Gatwick Airport Northern Runway Project – Development Consent Order (DCO)

Summary of Written Representations for Deadline 12th March

Gatwick Area Conservation Campaign (GACC)

12th March 2024

Diagram 3.3.9: Model performance before and after adjustment, London zone

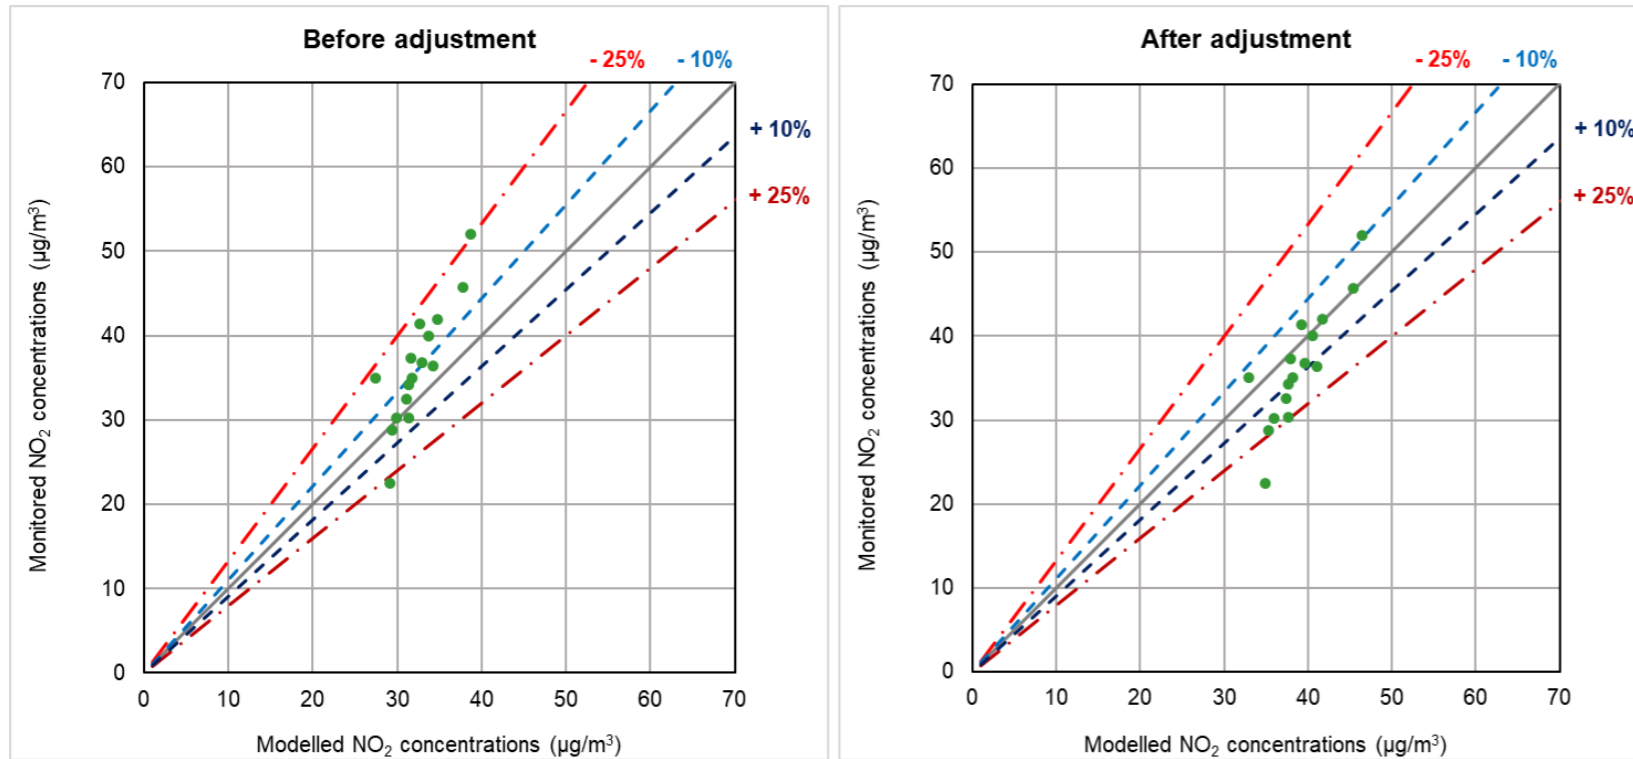
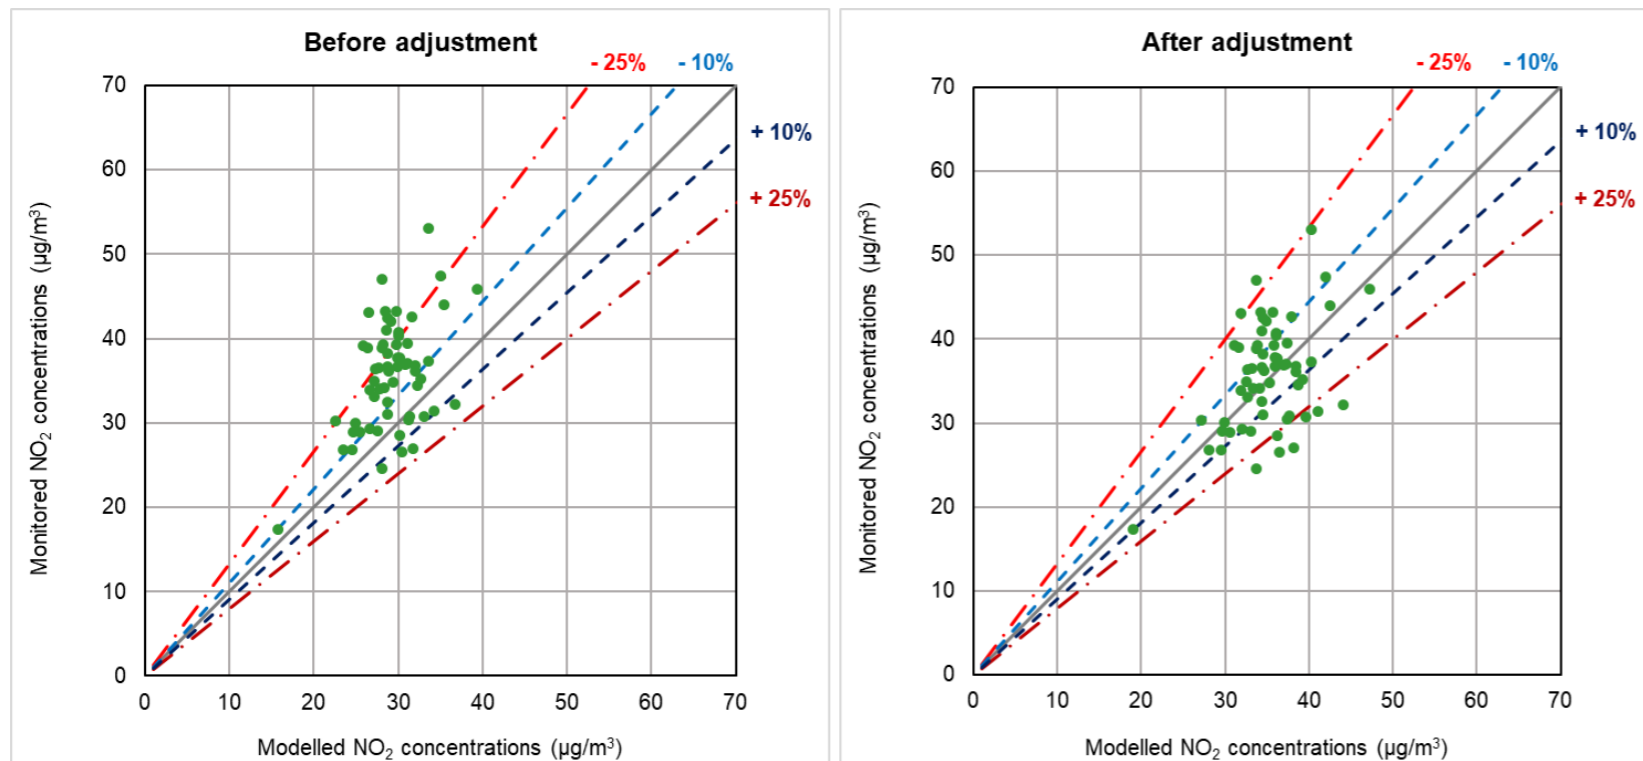
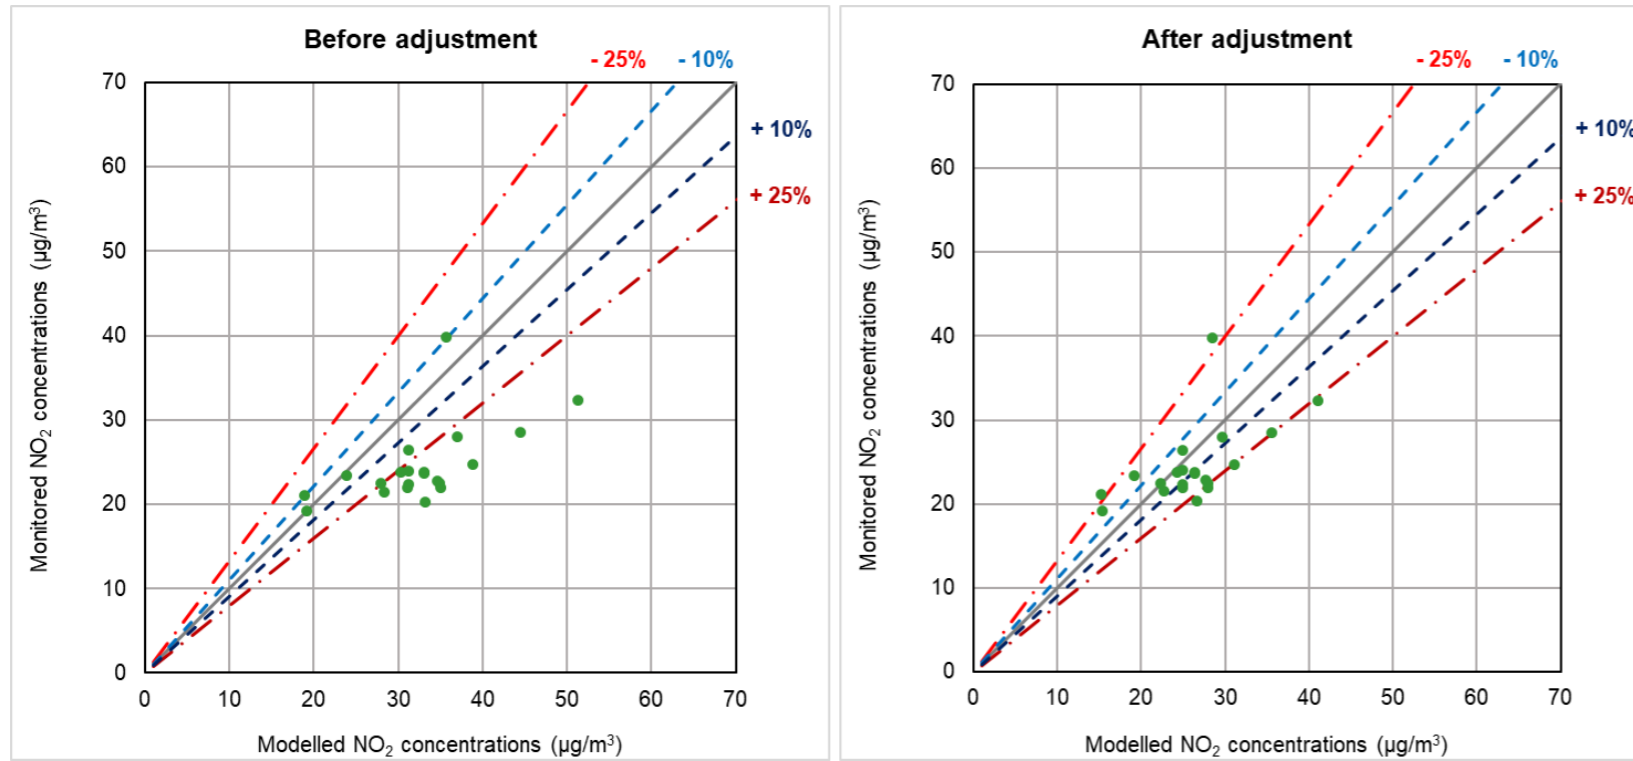
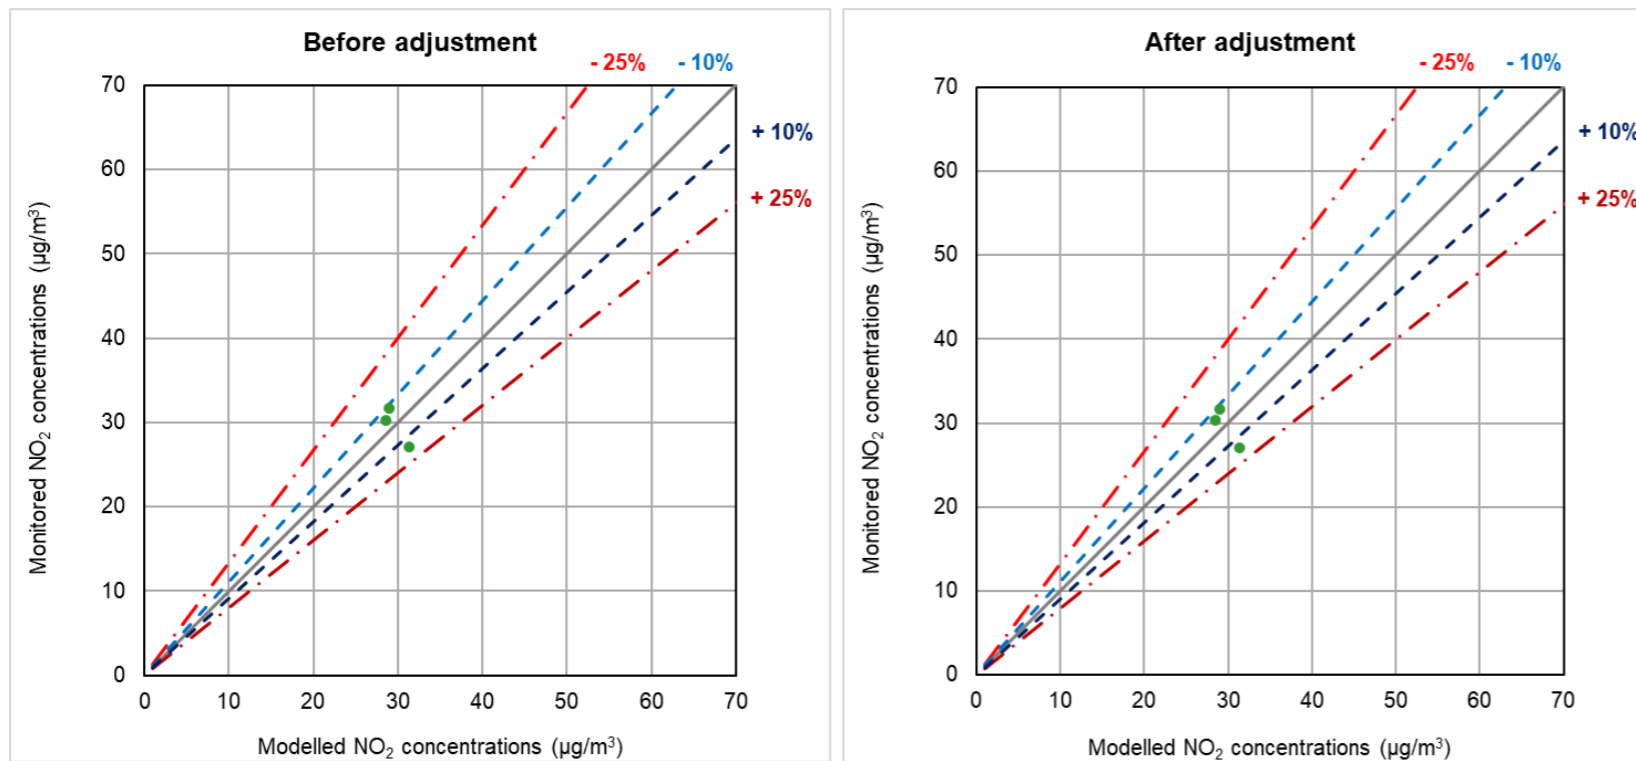
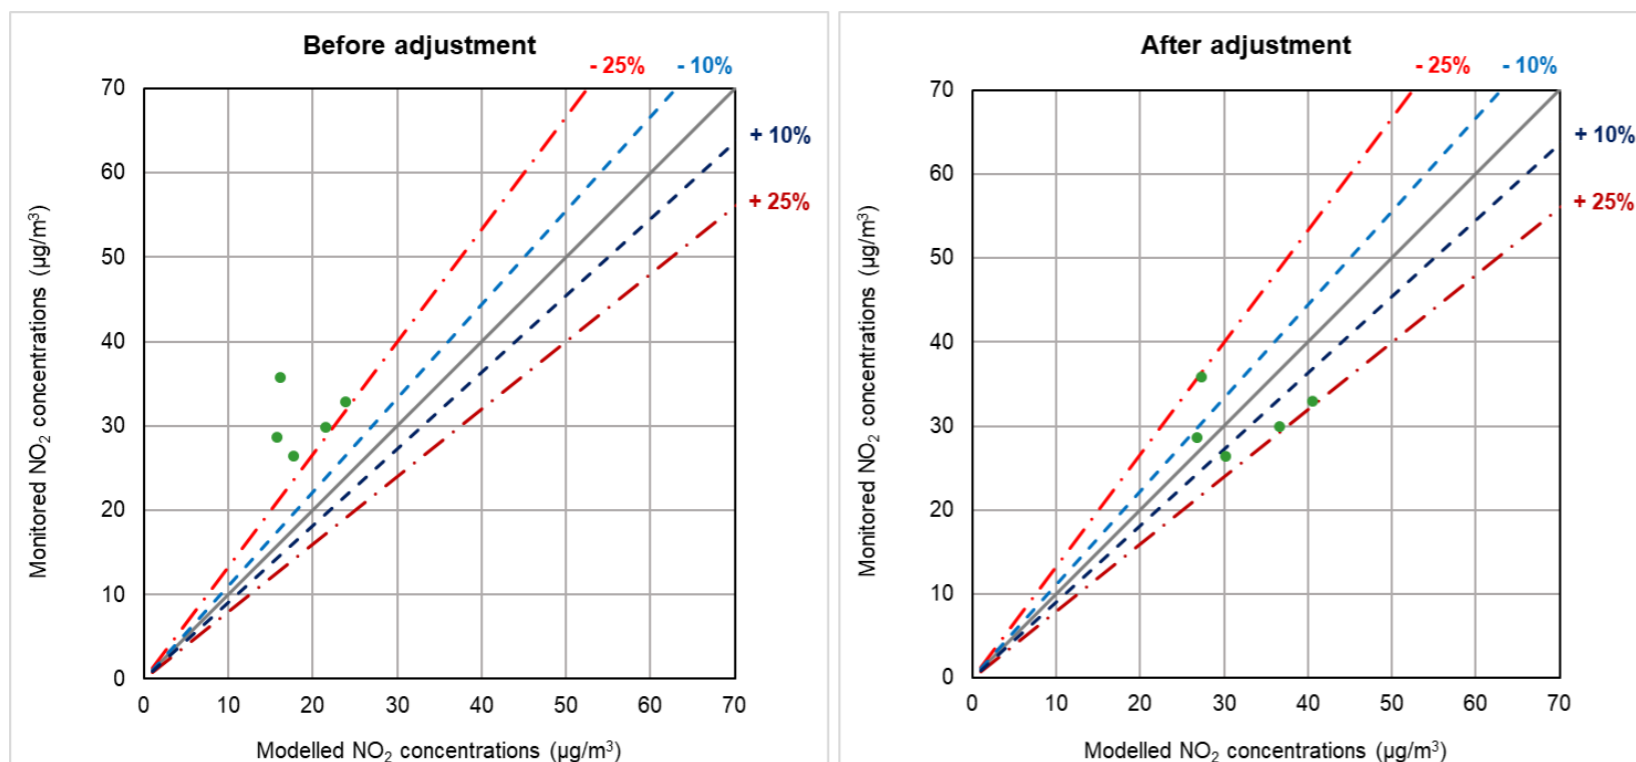
4. The confidence in the modelled air quality levels for future years is severely undermined by substantial inaccuracies in all of the aforementioned items. In particular the values for the baseline-modelled year (2018, especially for NO₂) are crudely adjusted to force a fit to the monitored air quality data. For this reason GACC propose that the model is made available for public scrutiny and that an independent statistical review is carried out to validate the assumptions and adjustments to better align the model data to the monitoring data and to review the quality of the monitoring data that is being used.

5. In our view, the modelling must not be relied upon to demonstrate that the future project impacts are not significant.
6. To make this data more robust, GAL should be required to annually review the accuracy of modelled data throughout the development stages, ensuring appropriate mitigation measures are in place should significant impacts be found. This should include reviews on the robustness of pollutant emissions inventories, with revisions of the air quality modelling to reassess and redefine the air quality impacts of the project at each stage to ensure no significant impacts are missed and not mitigated in a development of this scale. Furthermore, GAL should commit to substantially increasing the level of monitoring (covering the key pollutants of concern, particularly at sites vulnerable to project impacts e.g. schools, hospitals and homes likely to be impacted by an increase in road traffic or other airport-related emission levels) to ensure better quality baseline levels for future years upon which the project impacts are superimposed.
